From: Gary Ferrier [REDACTED]
Sent: 10 April 2017 17:08
To: Andrew Wood
Subject: RE: FG/198/16/PL - FW: Substitute amended Site Plan for informal advice at 1 Sea Drive

From: Andrew Wood [REDACTED]
Sent: 21 March 2017 11:11
To: Gary Ferrier <[REDACTED]>
Subject: FG/198/16/PL - FW: Substitute amended Site Plan for informal advice at 1 Sea Drive

FG/198/16/PL - FW: Substitute amended Site Plan for informal advice at 1 Sea Drive

JOB: 1 SEA DRIVE, FERRING, WORTHING BN12 5HD
DWG: PROPOSED SITE PLAN

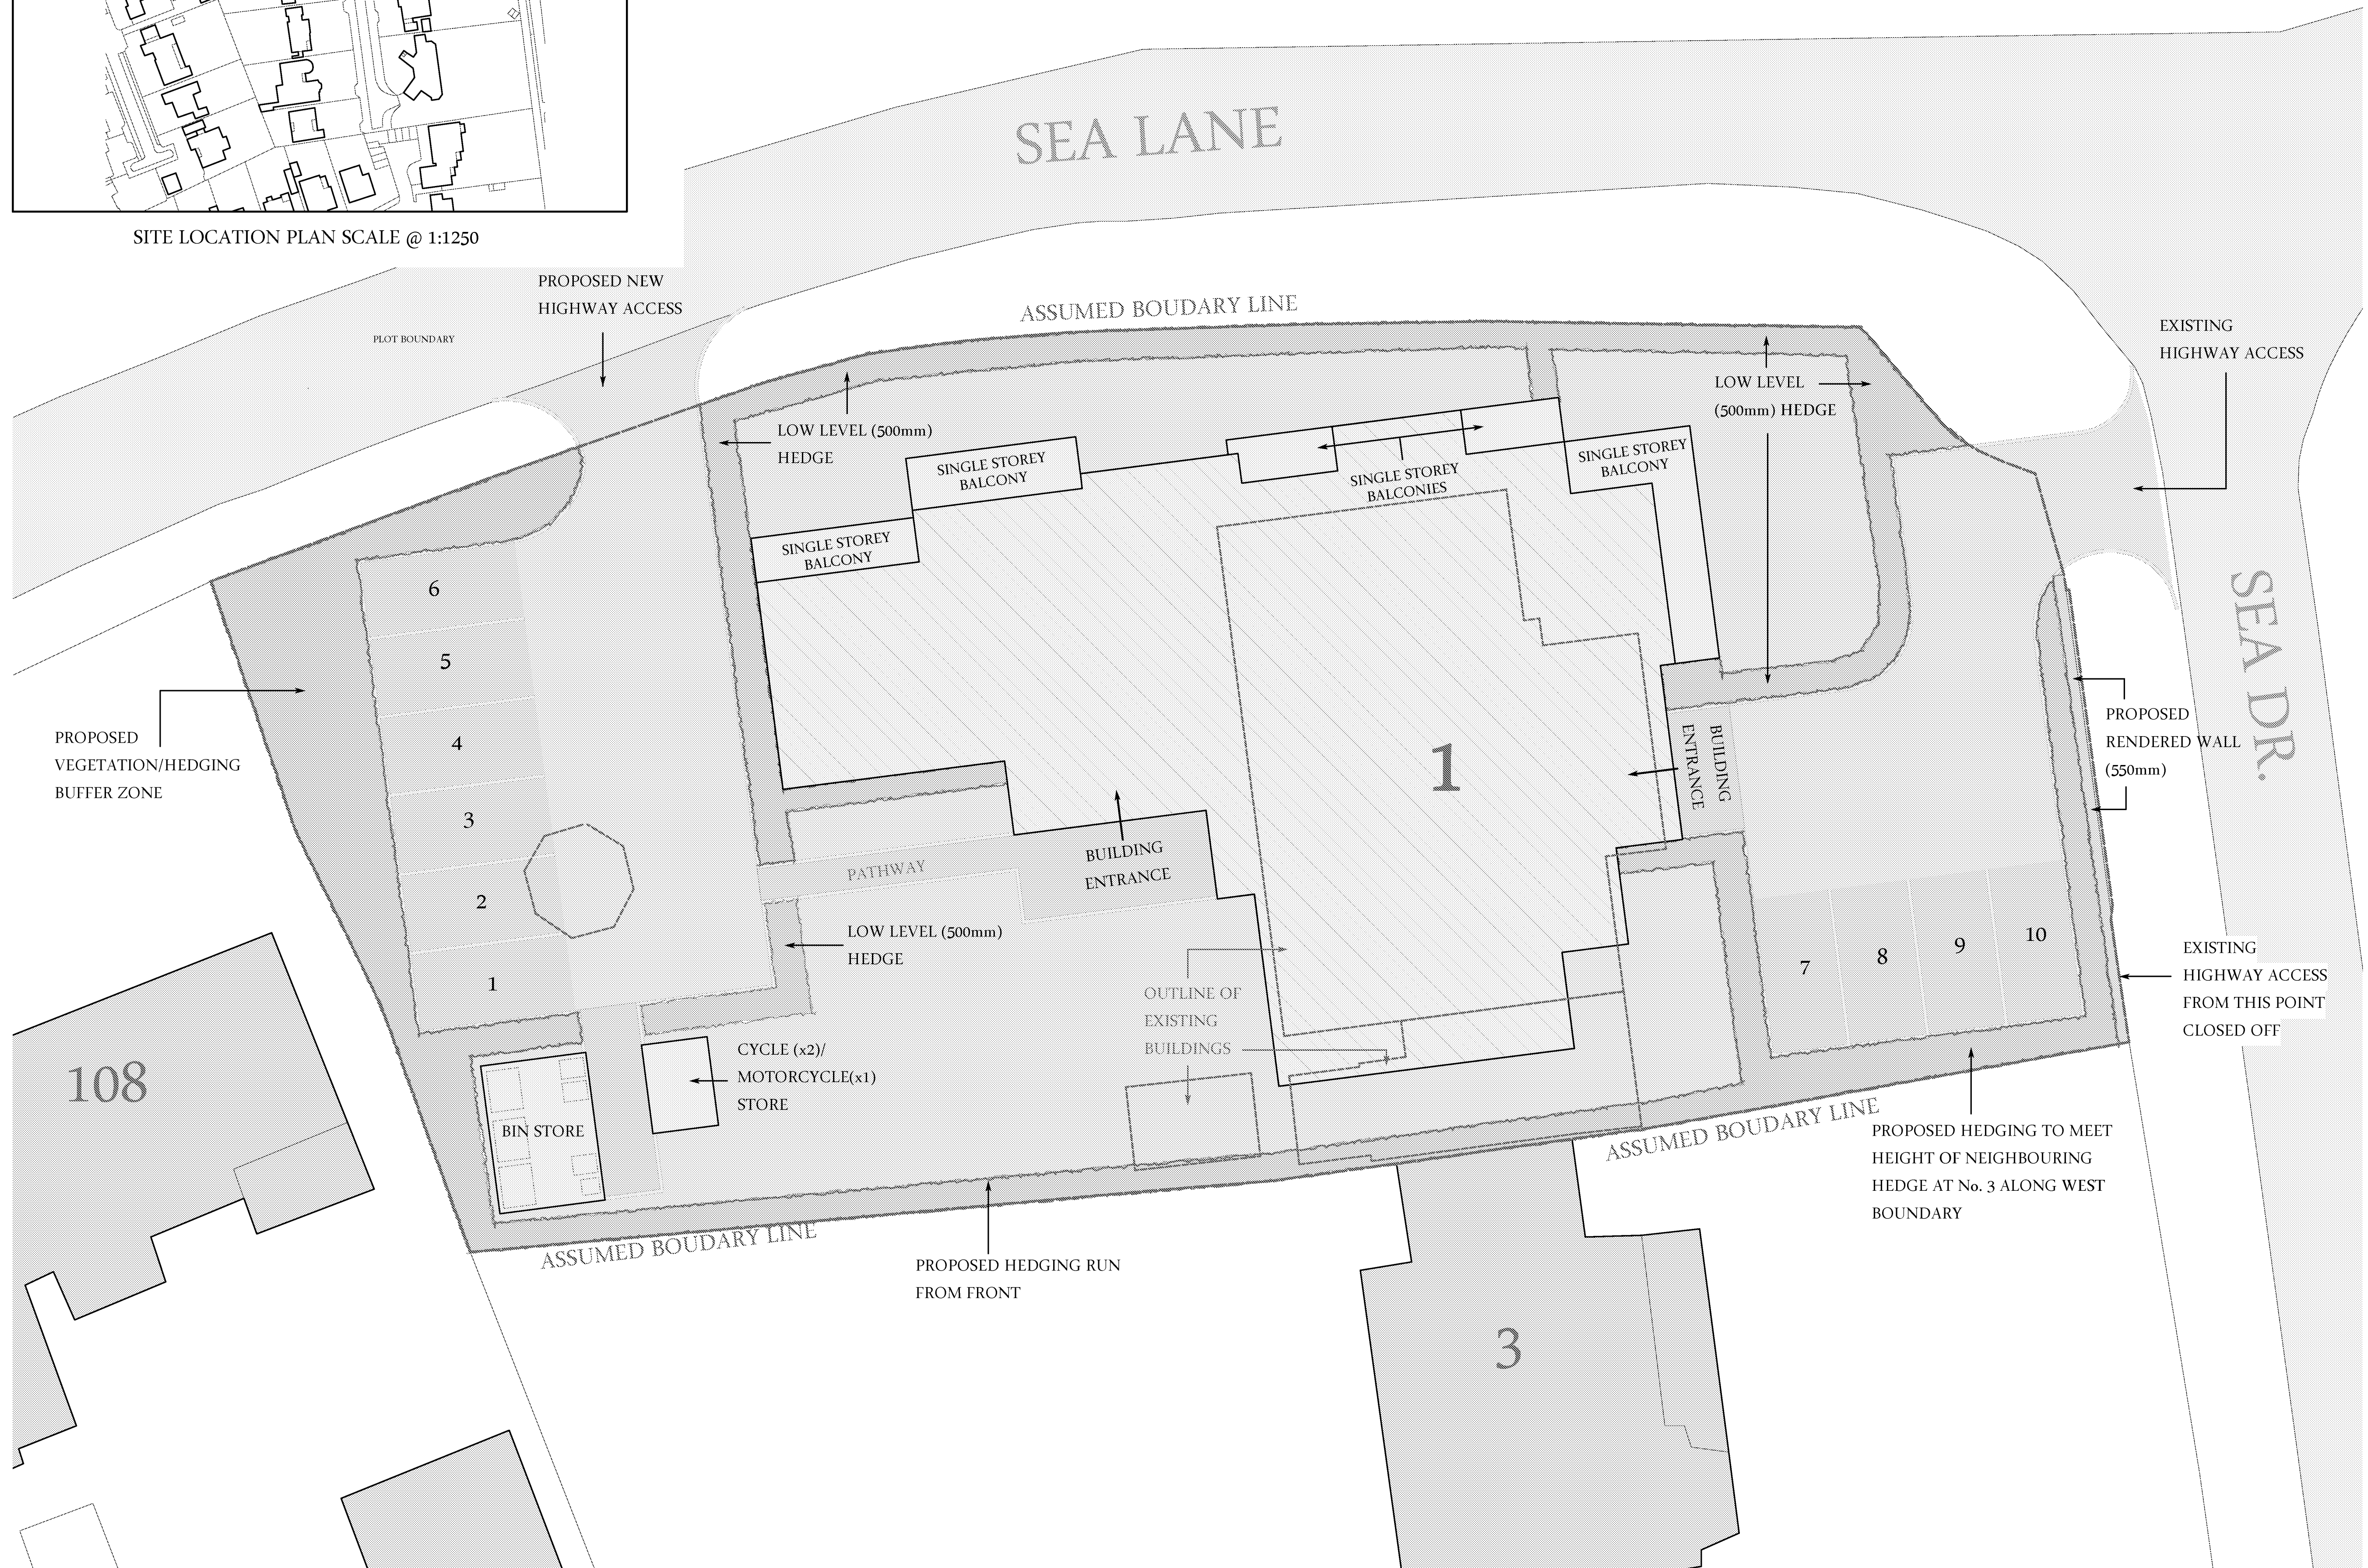
This does allow time for any final amendments to the scheme to take heed of the Highways Authorities suggested alterations as far as possible Officer Guidance i.e. swapping round the locations of the bin store with the parking spaces and/or finding a way to locate the car parking spaces so that cars can enter and exist in a forward gear, alterations to parking spaces 6&7 to ensure they can exit and enter the underground parking area in a forward gear.

The LHA would raise no concerns to the extra vehicles associated with the development entering or exiting onto Sea Lane (the adopted highway). As you are aware Sea Drive is a private roadway and the LHA have no jurisdiction over it, the LHA can however offer observations: parking bays 1 & 2 would appear rather close to the junction and it could cause a collision if vehicles are reversing into or out of these spaces whilst vehicles are entering or exiting the Sea Drive junction. Could these two bays be relocated on the site?

The access into the site and underground parking area appears to be 3m wide, this is not enough to allow two opposing vehicles to pass, shared access should normally be 4.5m, unless passing places are in situ; however given the frequency and low number of vehicular movements it is not considered that this would lead to any material impact on the local highway network that could be considered severe.

The underground parking area appears tight, vehicle tracking should be provided to demonstrate this is workable. In particular there is no turning head, it may be difficult for vehicles to get into and out of bays 6 & 7 and should a vehicle enter and all spaces are taken then it would involve them reversing out up the ramp, this is not ideal.
